19/01419/DISC

Cedar Lodge, North Side, Steeple Aston

Discharge of condition 4 (schedule of materials), 5 (cross section and colour / finish), 7 (French drain details) and 8 (stone floor method statement) of 19/00532/LB

rev.	description	date	drn	ckd
1	first issue	06.06.2019		
2	scale	1:50 @ A3	drawn	TW
3	dwg. no.	2018-1014-GA03

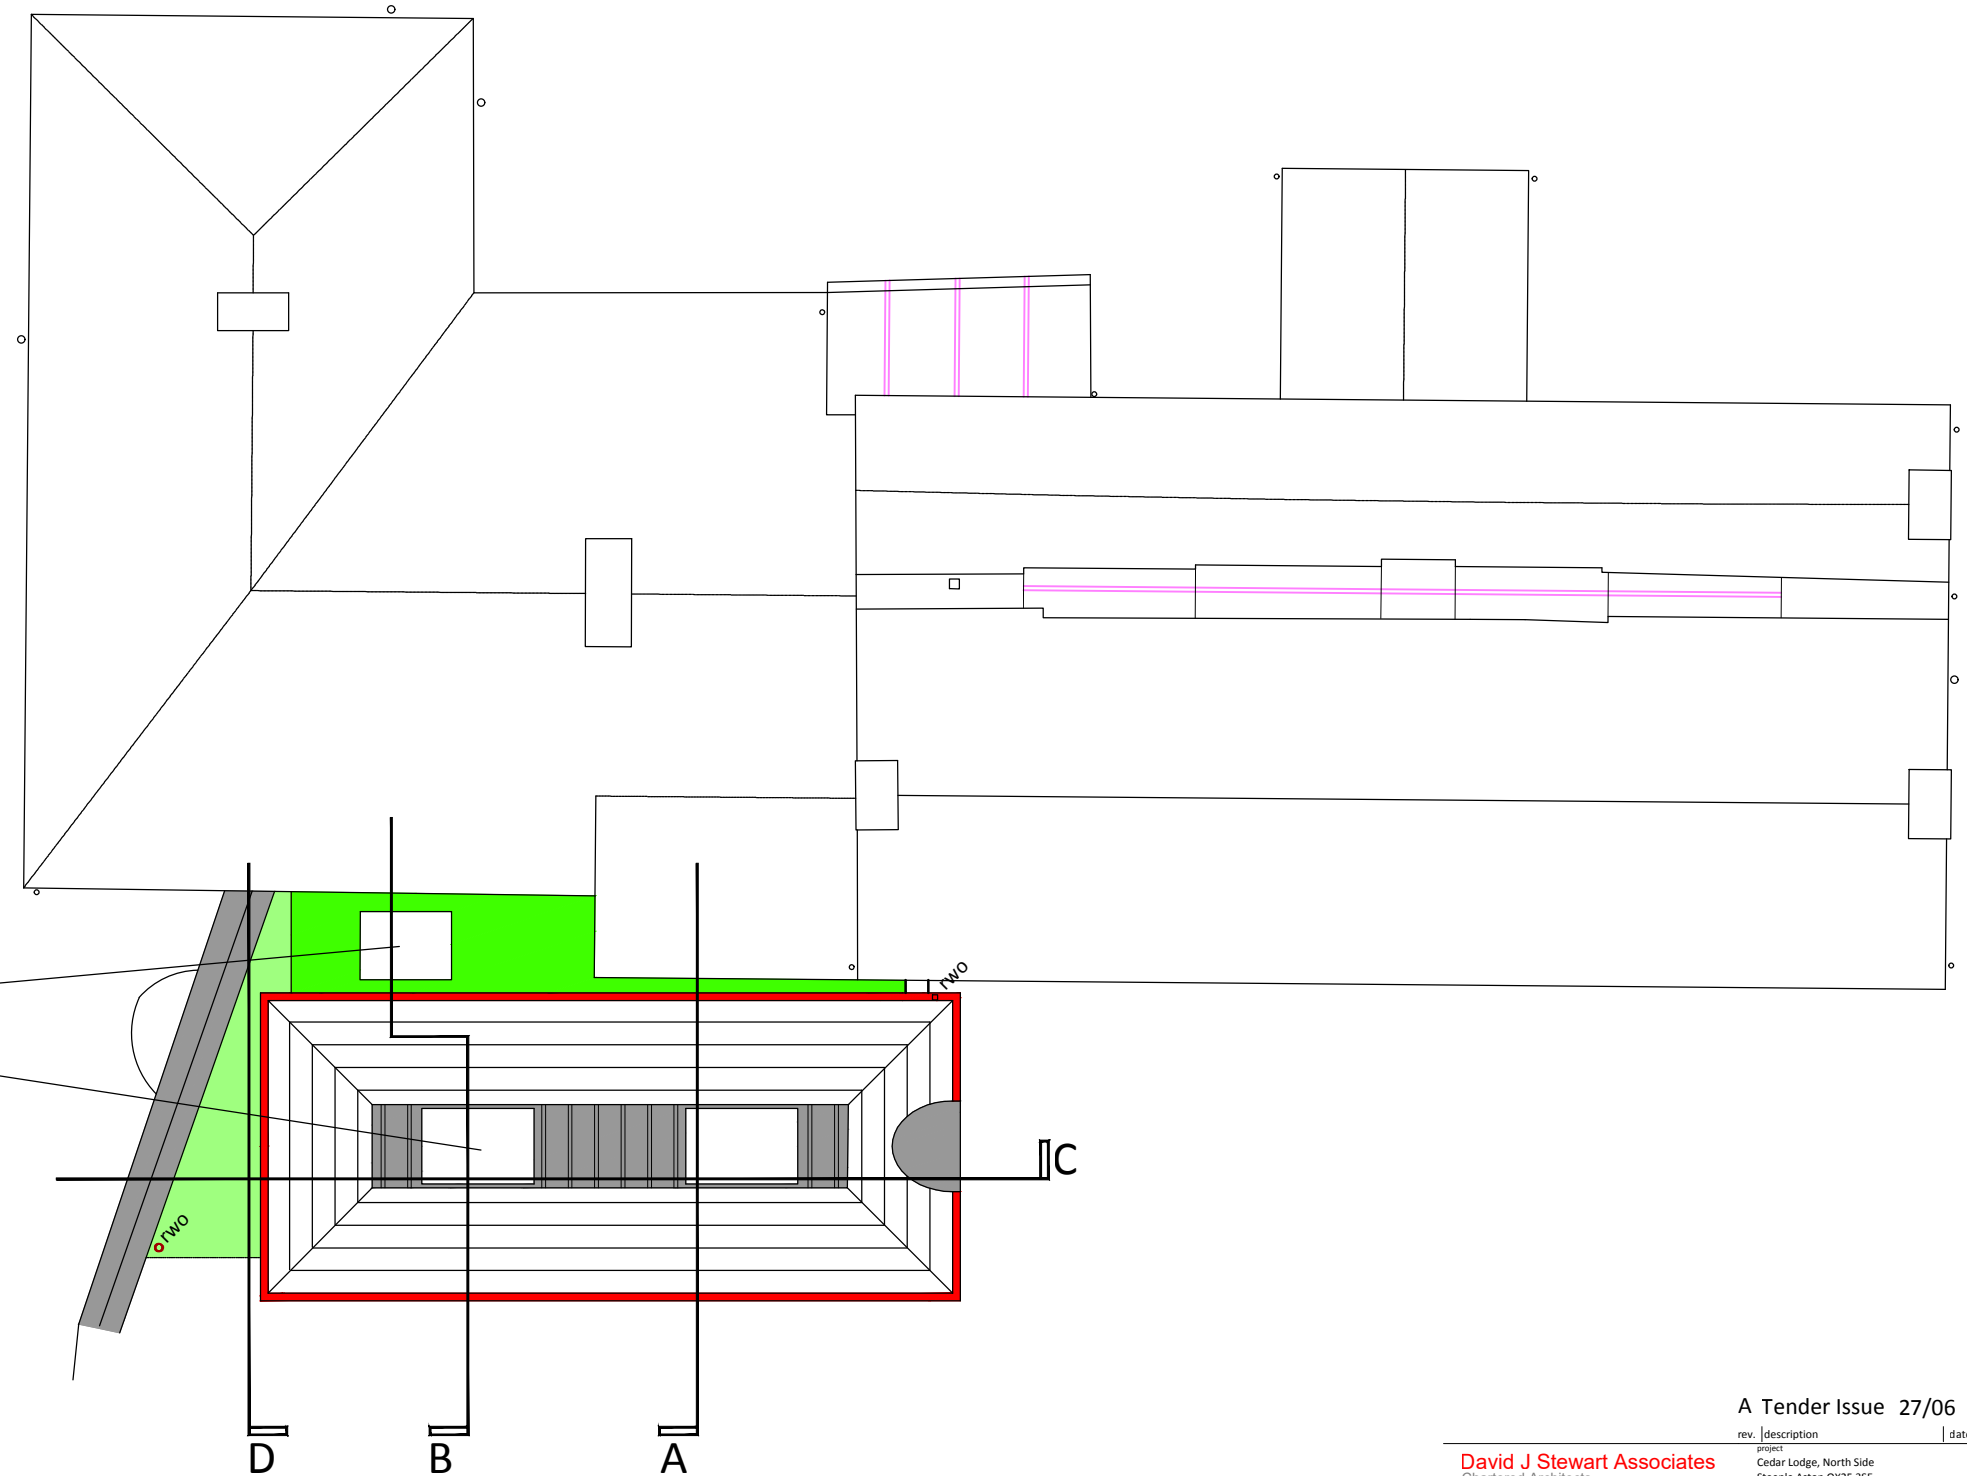
- There are no objections to the use of blue / grey slate, but further details or a sample are required. The quality and provenance of the slate will be the key issue.

- There are no objections to the use of ply membrane on the linking sections of the roof.
- There are no objections to the use of lead on the top of the roof extension, but concerns that lead is shown wrapping over the existing stone boundary wall.

project	Cedar Lodge, North Side Steeple Aston OX25 3SE		
title	Sections A-A, B-B, C-C and D-D		
first issue	06.06.2019	checked	djs
scale	1:50 @ A3	drawn	TW
dwg. no.	2018-1014-GA04	rev.	A

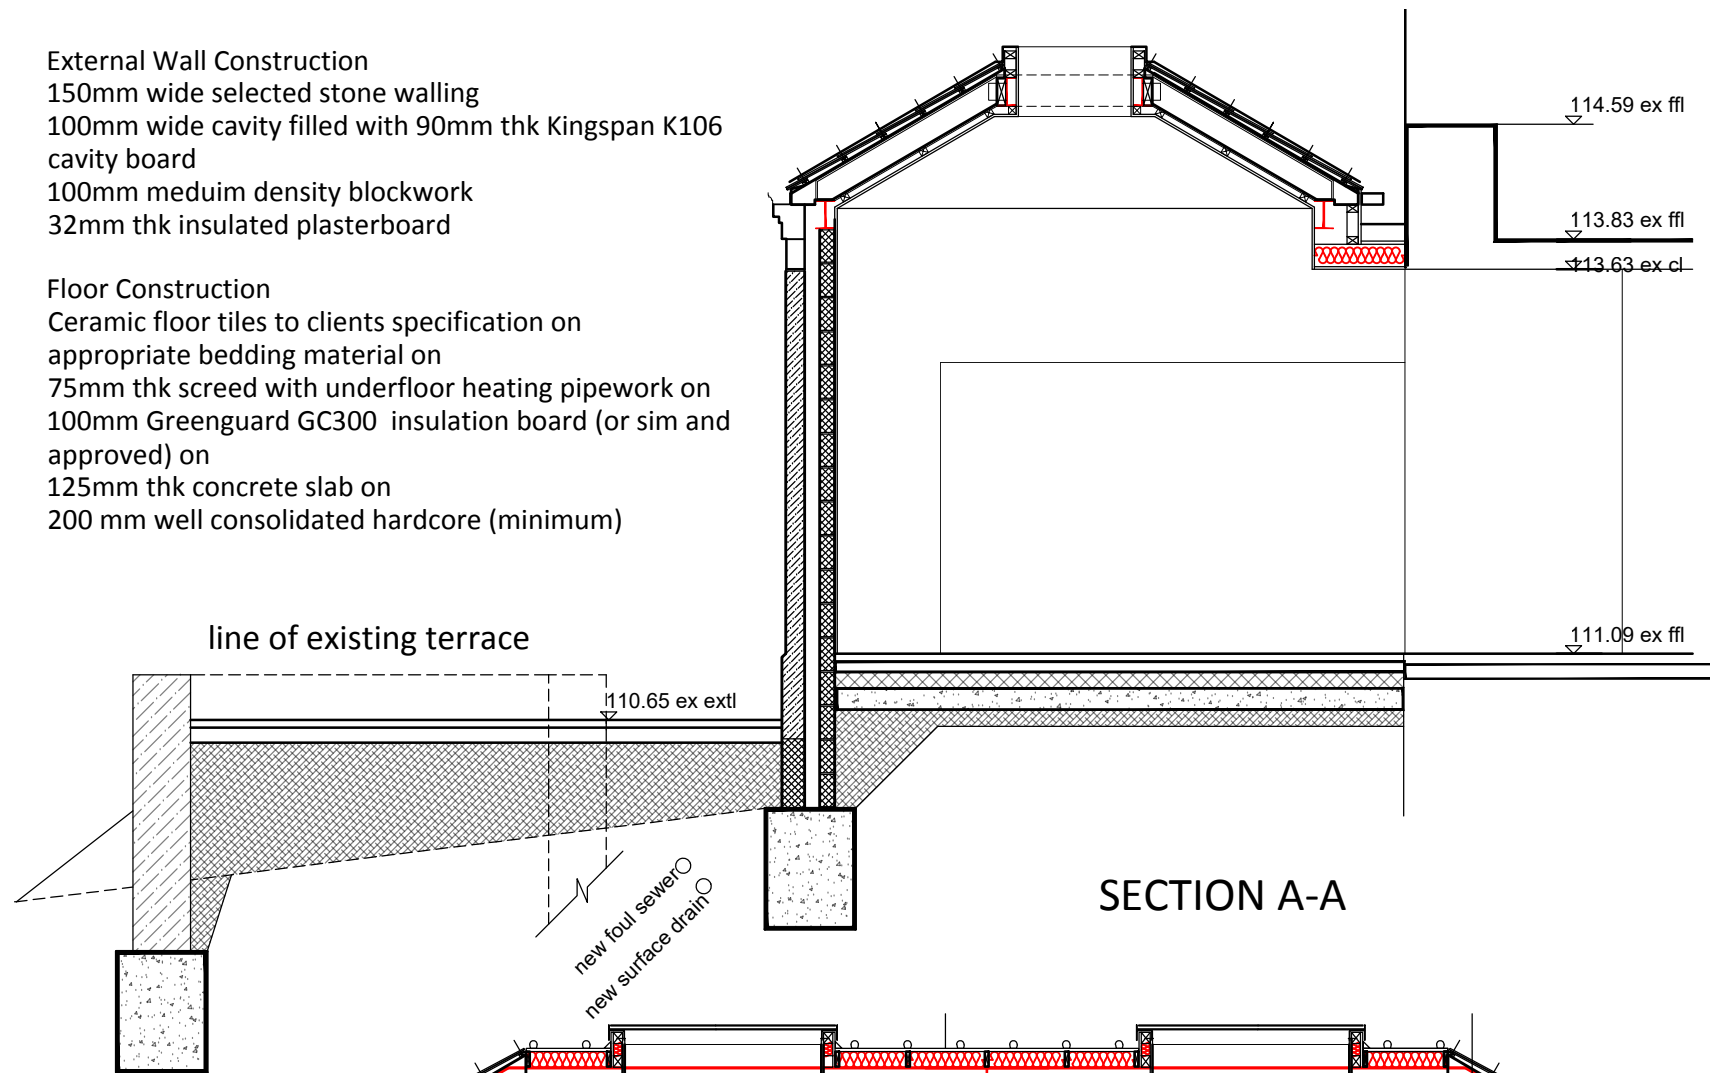
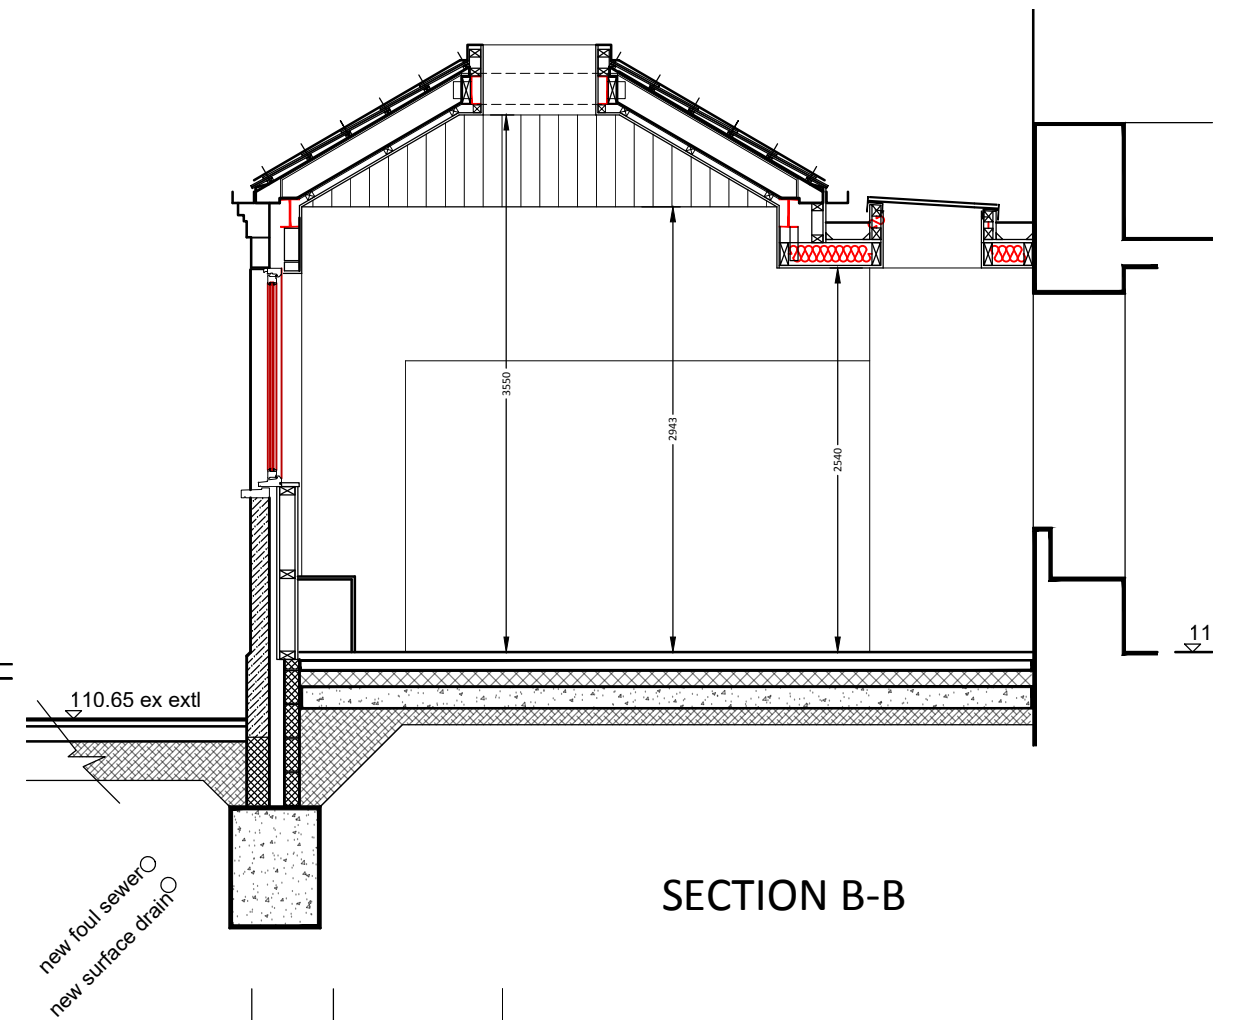
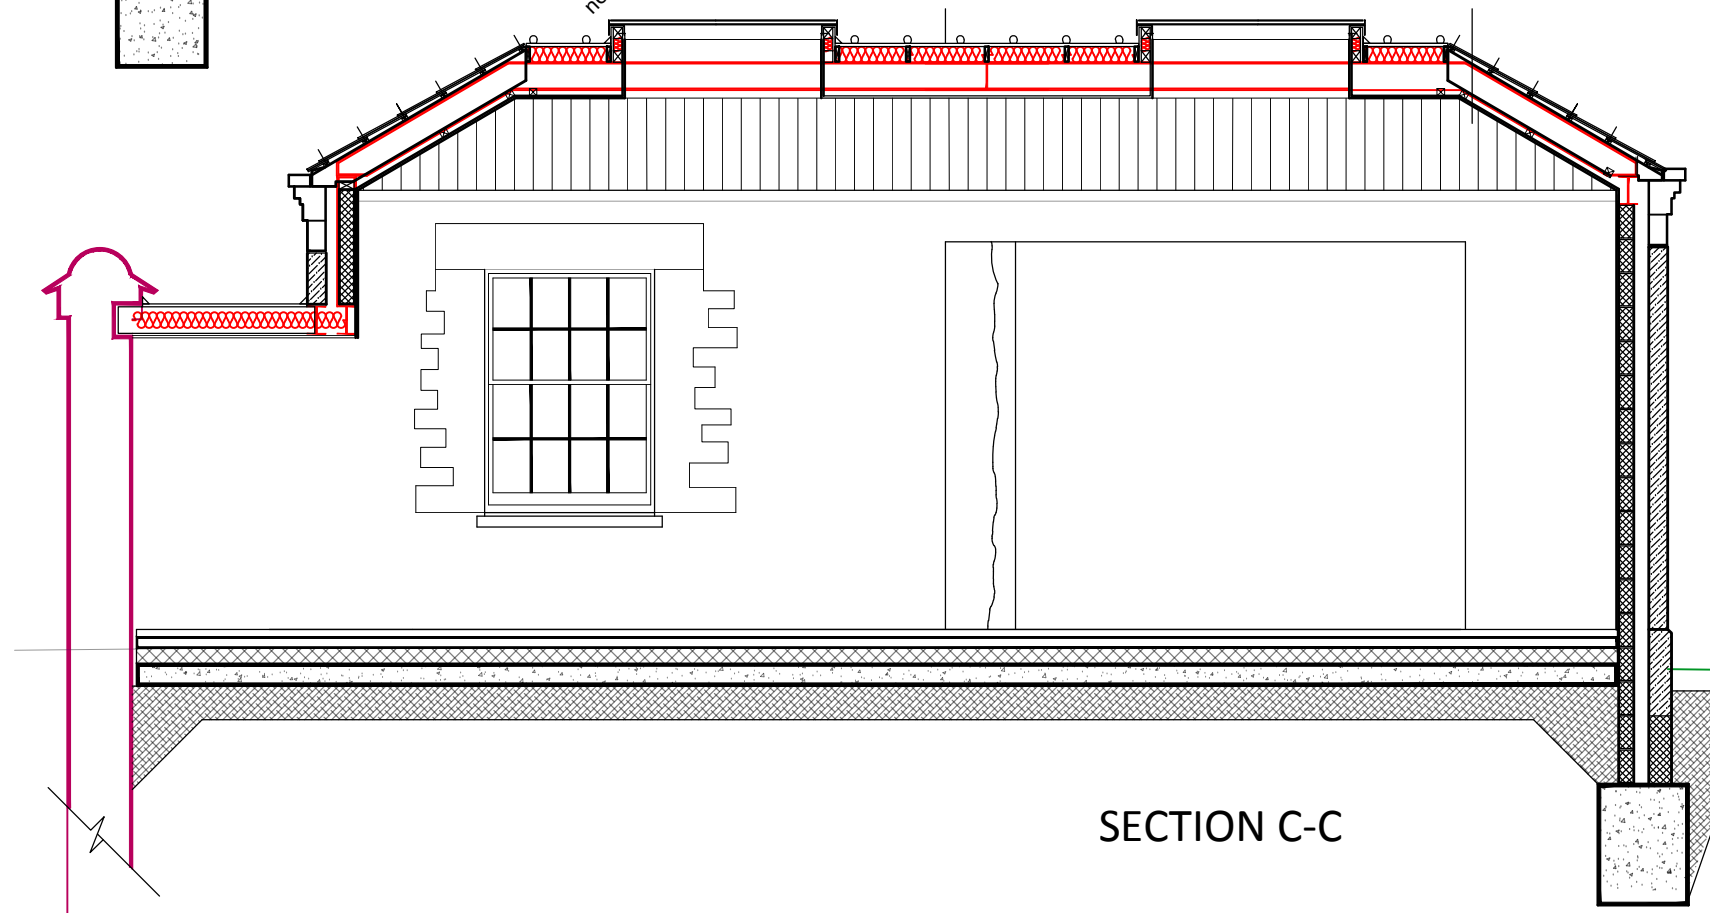
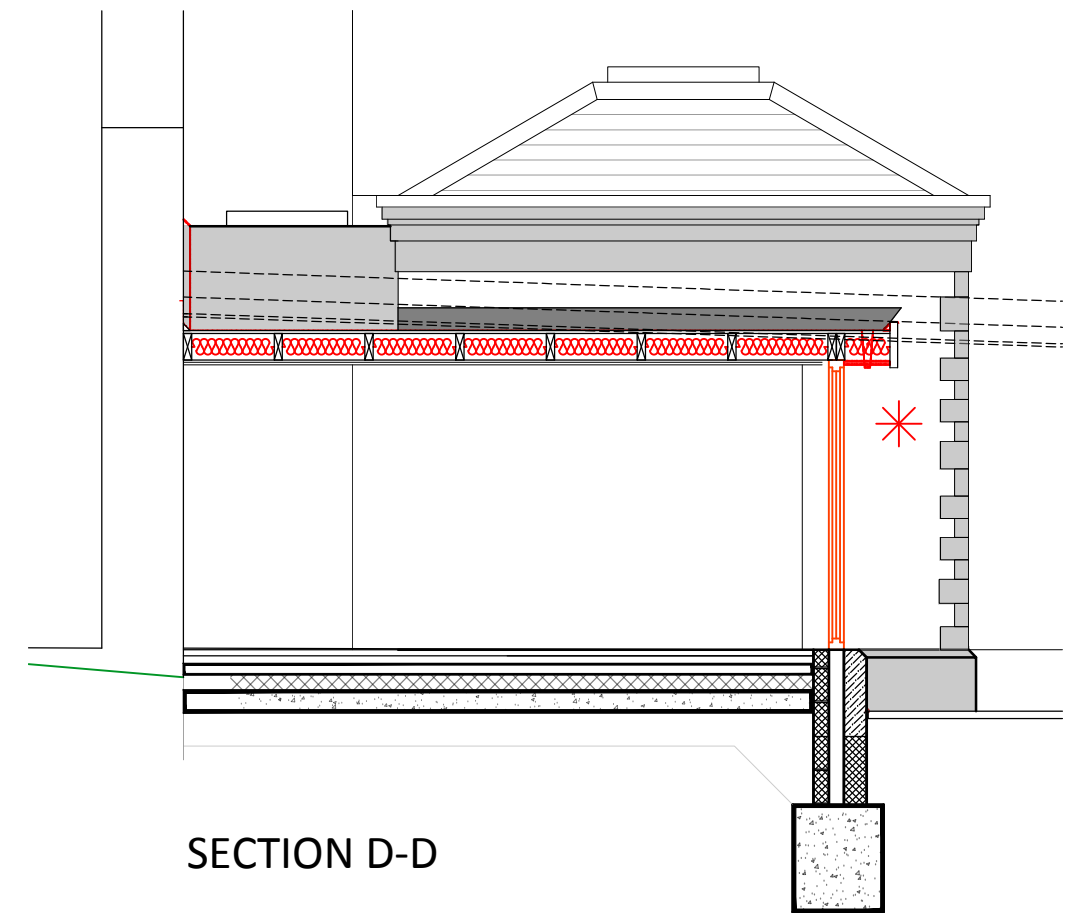
- There are no objections to the use of Stoke Ground base bed for the ashlar / architectural details, but a sample should be provided.
- Further details are required of the proposed stone to be used on the walling of the extension and a sample to be provided. This is of particular relevance as the intention is that it should match the main house.

A Tender Issue 27/06 tw	
rev.	description date dnm ckd
project	
Cedar Lodge, North Side	
Steeple Aston OX25 3SE	
title	
South and East Elevations	
first issue	06.06.2019
checked	djs
scale	1:50 @ A3
drawn	TW
dwg. no.	2018-1014-GA06
rev.	A

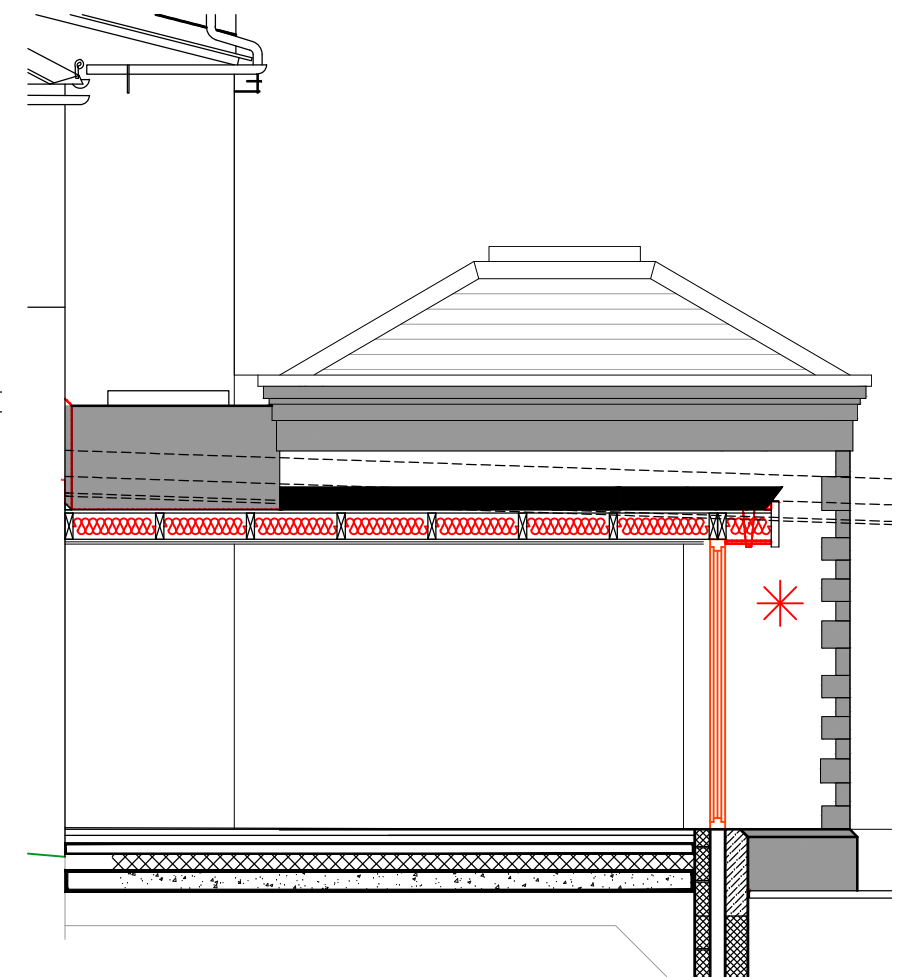
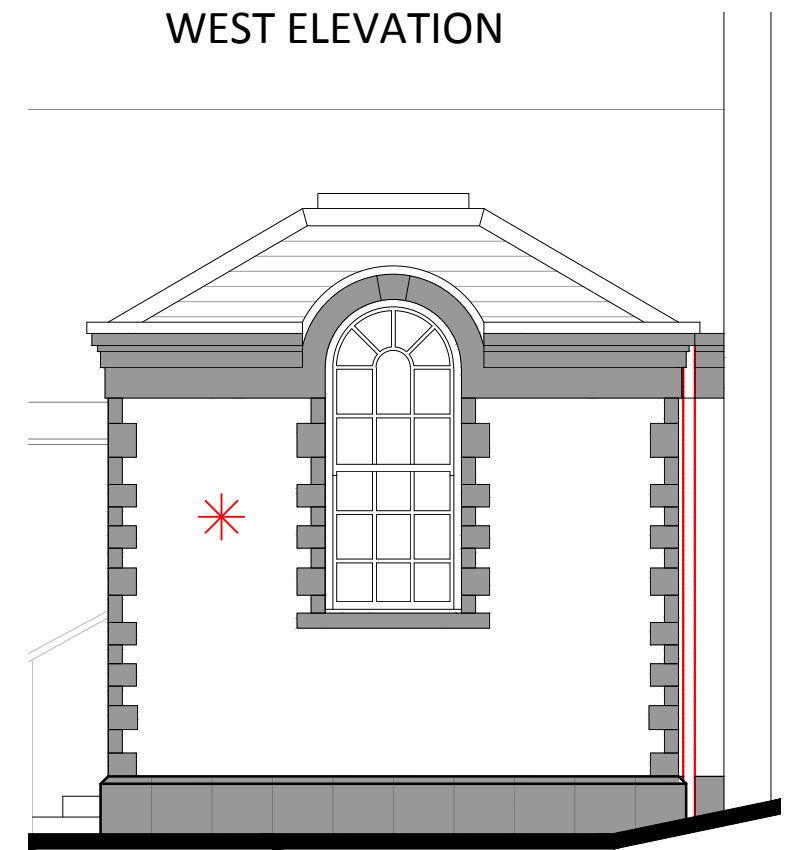
- Details are required of the 'openings' ( windows and doors) to the extension.
- The details submitted as part of the additional information for the doors and windows to the extension show standard double glazing with applied glazing bars. This needs to be slimlite double glazing with integral glazing bars.
